Department of Planning, Industry and Environment  
GPO Box 39  
Sydney NSW 2001  
Attention: Lisa Mitchell

19 December 2019

## **Re: Sydney Gateway Road Project – SSI-9737**

Figure 19.14 Project land requirements

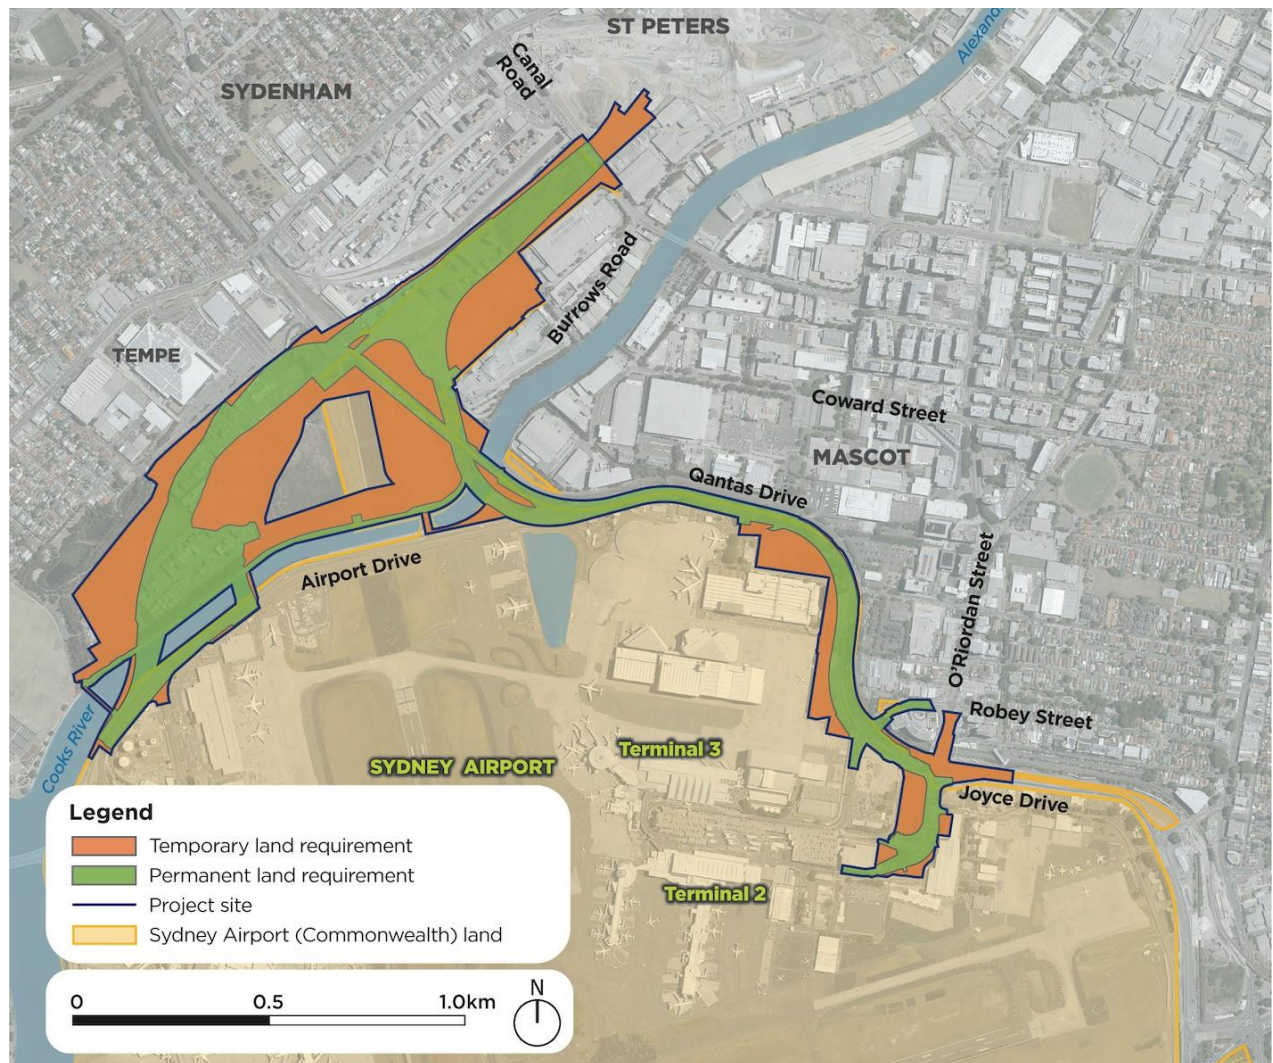
The plans exhibited with the EIS identify the operational development footprint of the Sydney Gateway Road project and includes land at the Cooks River Intermodal Terminal site. The Cooks River Intermodal Terminal is a staging point for containers, an empty container depot with repair and washing services, and an intermodal facility for regional and port shuttle trains. It forms a vital port-supporting asset in the supply chain and the operational efficiency of the site is paramount to NSW Ports.

In order to respond to the demands of the empty container supply chain, land availability at Cooks River is of vital importance. As such, NSW Ports stresses the need to minimise the amount of land that is resumed or sterilised to construct the Sydney Gateway Road project.

Given the importance of the site outlined above it is critical that the alignment of the Sydney Gateway Road project does not encroach on or sterilise any part of the Cooks River Intermodal Terminal site and alternate design solutions be finalised to avoid any disturbance to land or operation at the intermodal terminal.

If the Sydney Gateway Road project has development options that no longer traverses Cooks River Intermodal Terminal land, revised design plans should be presented. Further, NSW Ports will require the opportunity to review the revised plans for any adverse impacts which may result to the Cooks River Intermodal Terminal as a result of the road alignment.
